**DEVELOPMENT REVIEW BOARD
ACTION SHEET**

DRB CASE NO/PROJECT NO: 1003262

CITY OF ALBUQUERQUE
PLANNING DEPARTMENT
SEPTEMBER 8, 2004
DRB Comments

RE: Regulation & Licensing Dept/Amend. SPS

SITE DEVELOPMENT PLAN for SUBDIVISION

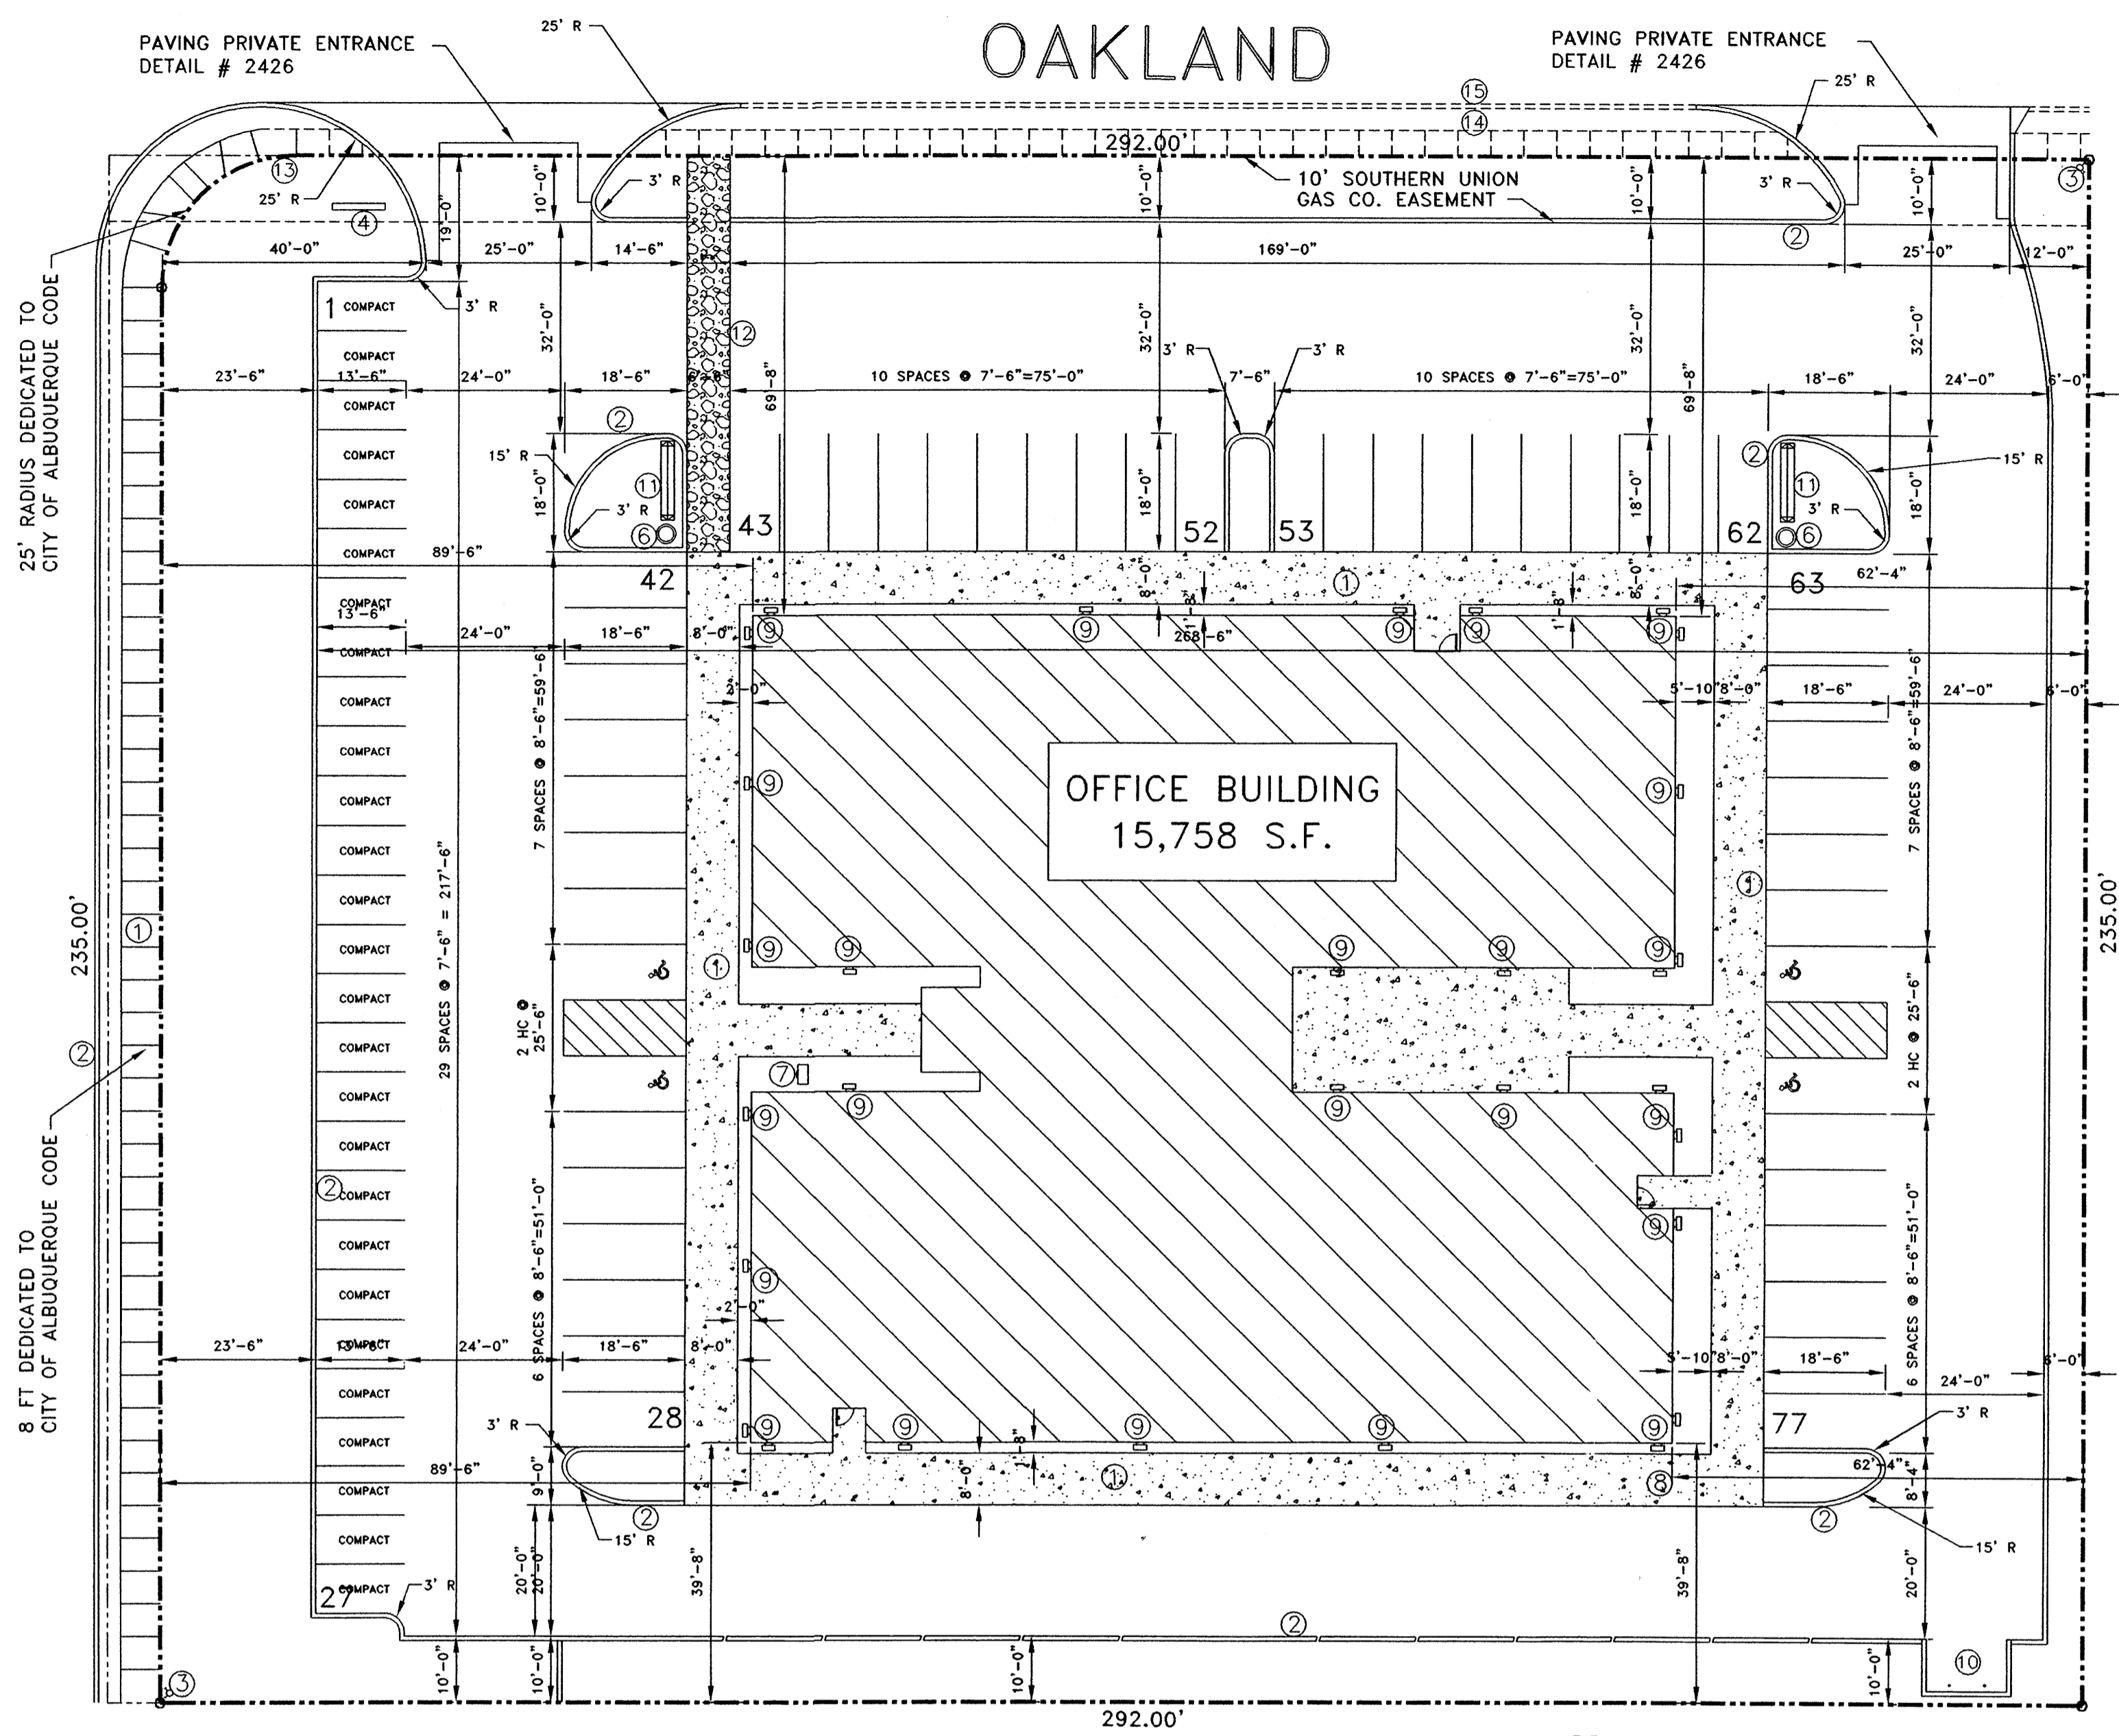
Applicant was called on 9/2/04 and told he could not move a signed DRB signature block onto a site plan with changes we did not approve. This problem was corrected and a new Site Plan for submittal provided. However, we still do not have 3 copies of the original, approved site plan for our files as required.

Some of the changes on the amended site plan were not clouded as required on the new submittal brought in on 9/3/04. In addition, the signature block to sign the amended site plan still has the unnecessary language above the signature lines.

LANDSCAPE PLAN

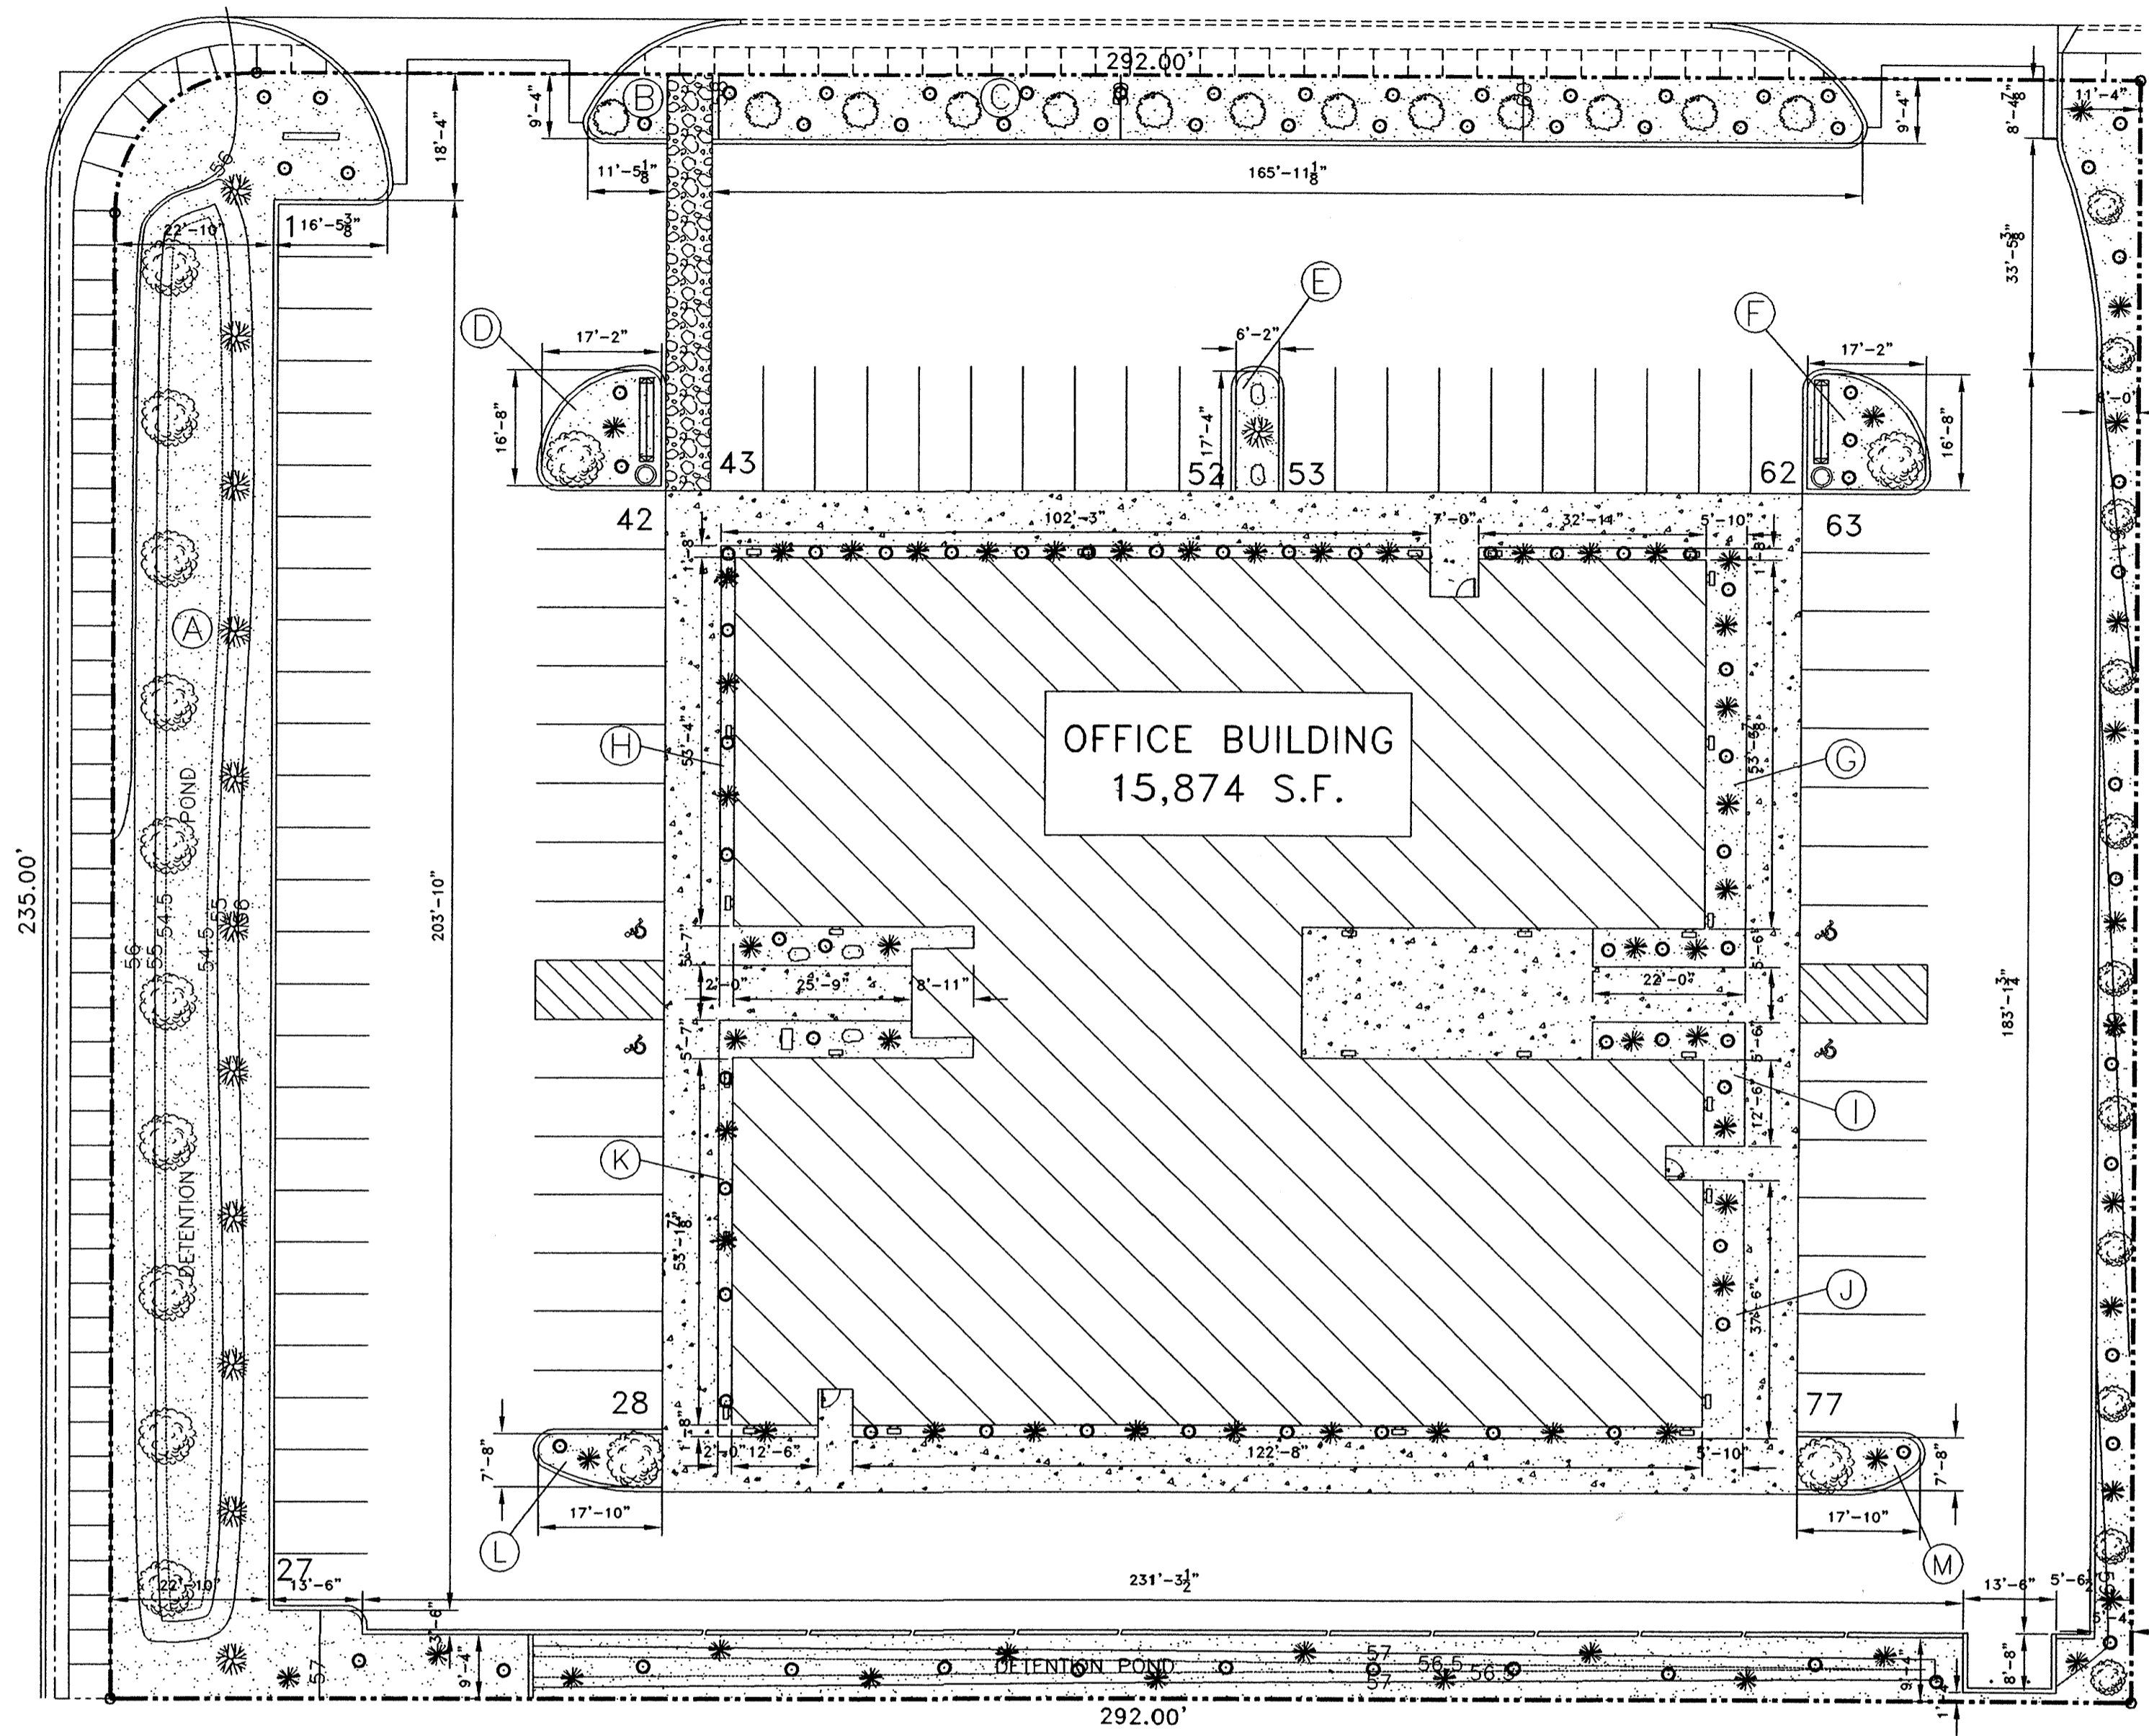
The revised landscaping plan was not submitted by 2pm. Therefore, this case will be deferred until September 15, 2004 by the Board. A fee will be paid by the applicant.
